Application No: M/91/21/PL
Site Address: 27 Central Drive Middleton-On-Sea PO22 7TT
Description of works: Variation of condition 2-approved plans & removal of condition 4-materials included on plans imposed under M/25/19/PL.

Thank you for your internet representation made on 20th July 2021 which has been recorded as an objection with the comments as follows:

PROJECT	27 Central Drive - Elmer Beach	DATE	16/09/18
TITLE	Proposed South Elevation	DRG NO	IBA/507/05
SCALE	1 : 50	REVISIONS	B

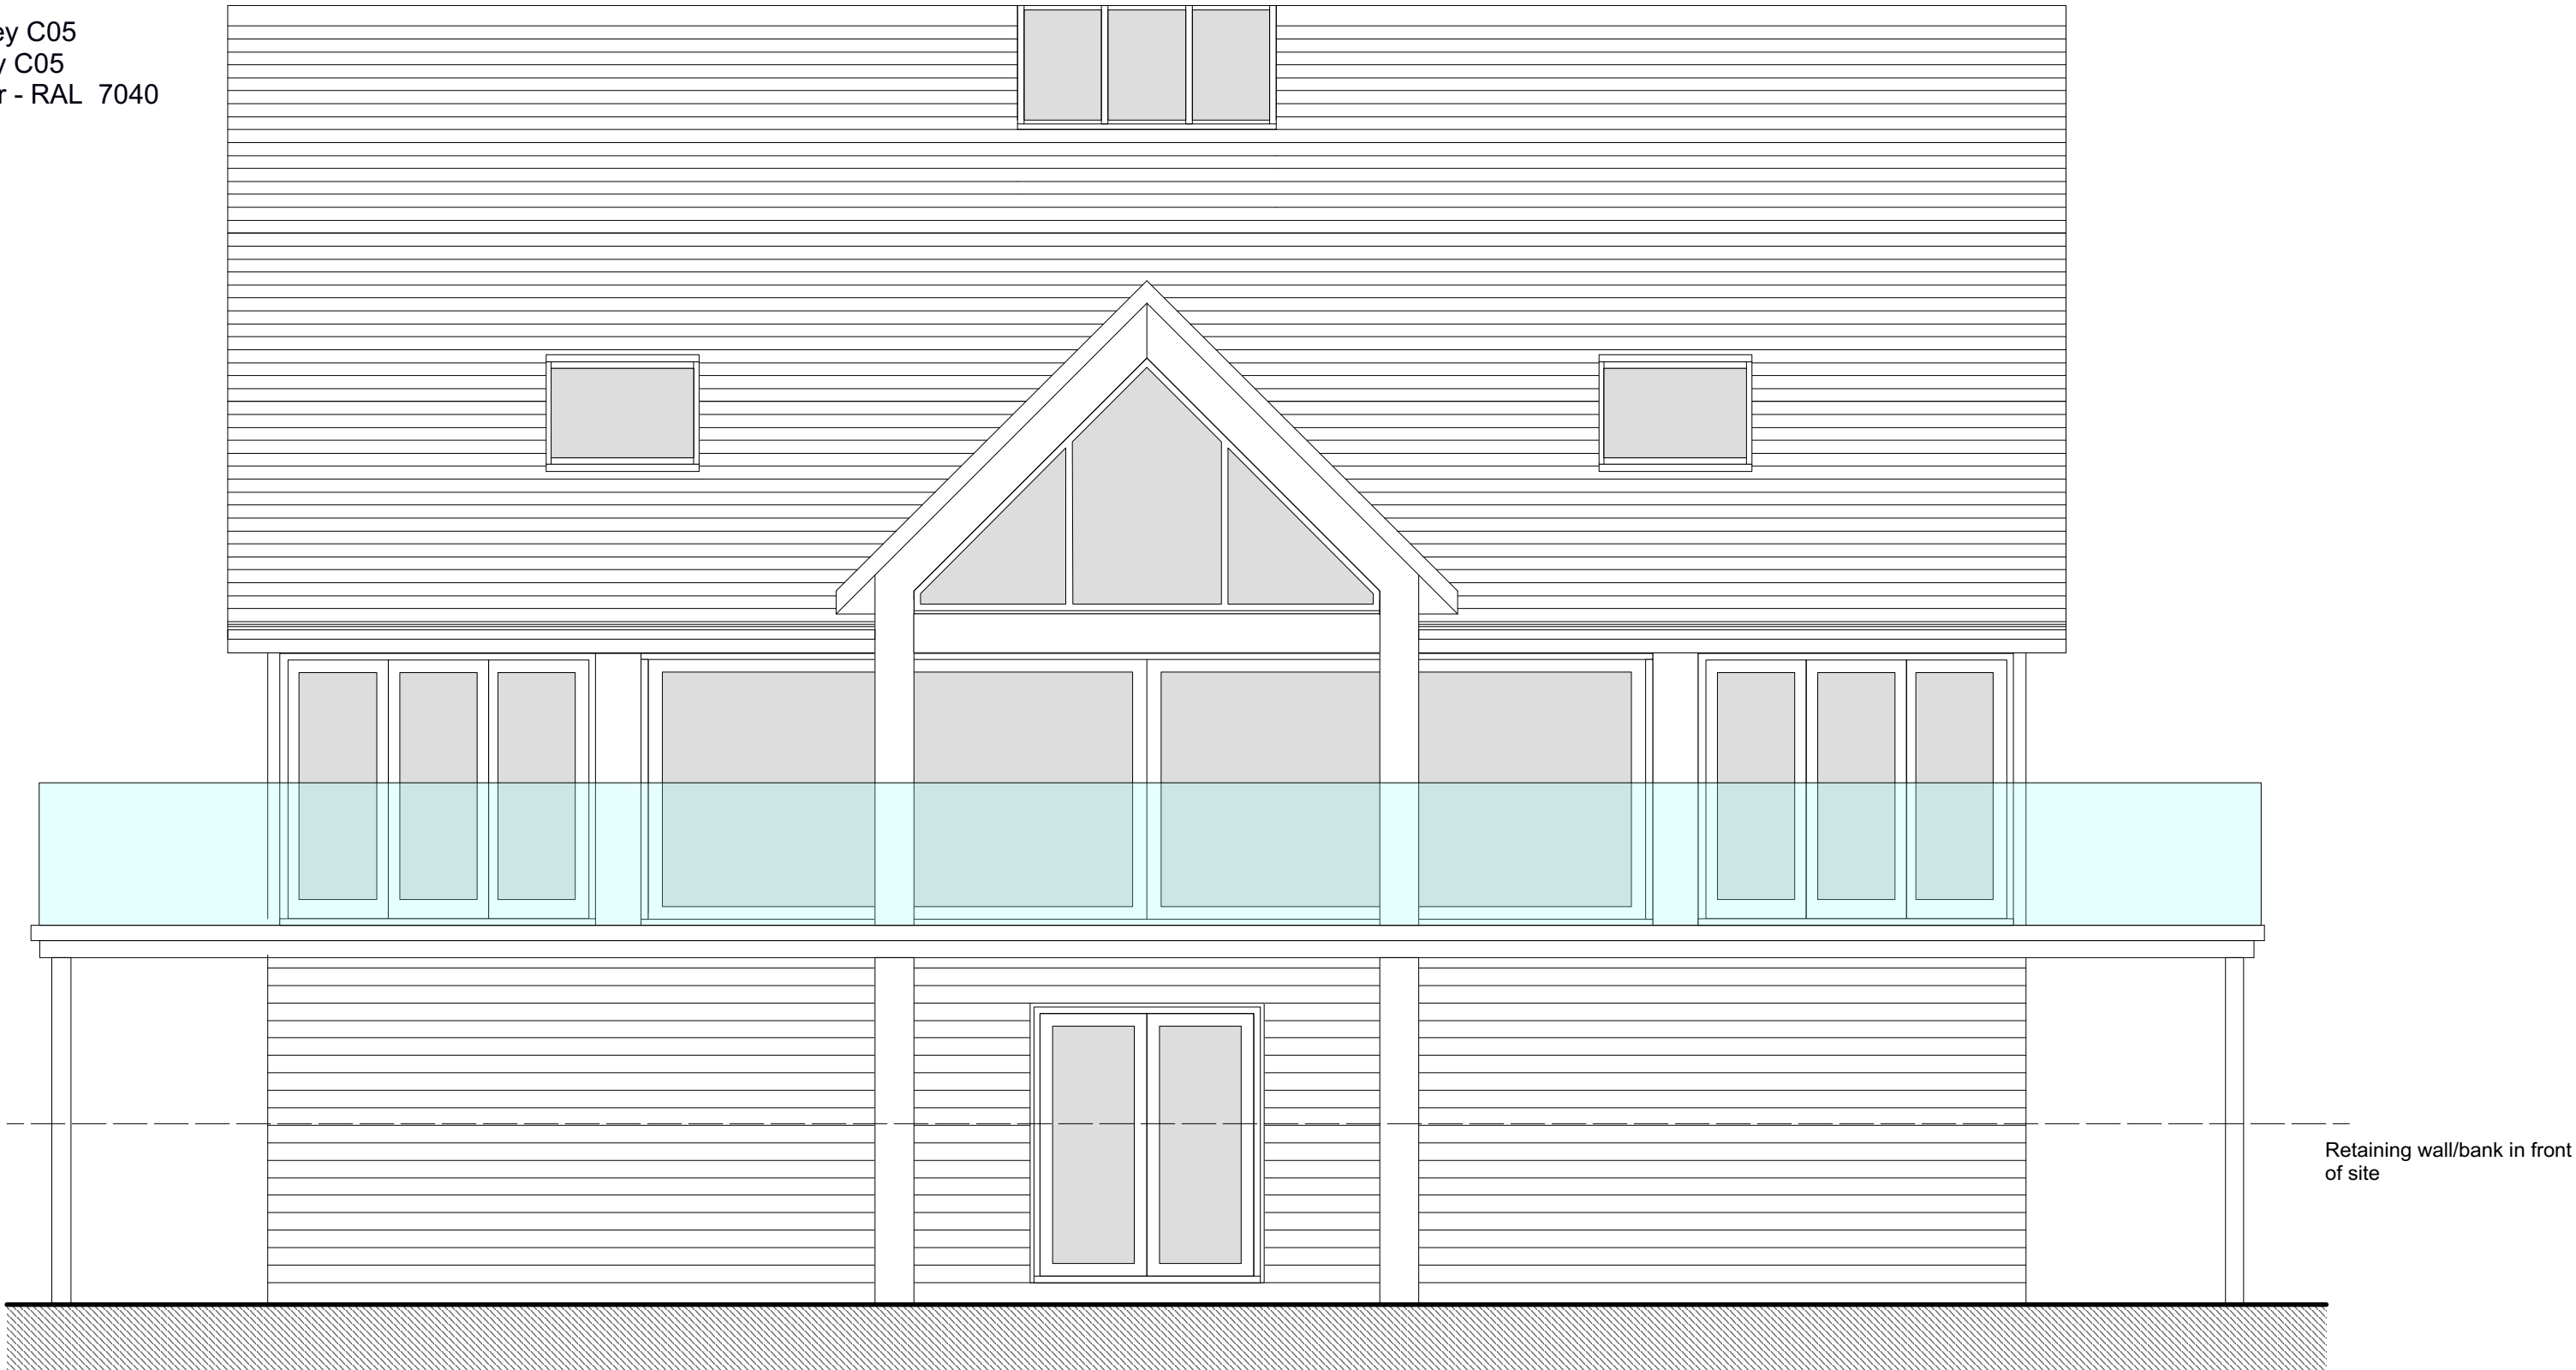
This proposed amendment goes against the Arun local planning policy on design (D SP1). The roof height is too high compared with neighboring properties and so it would dominate the view of houses from the beach and coastal path.
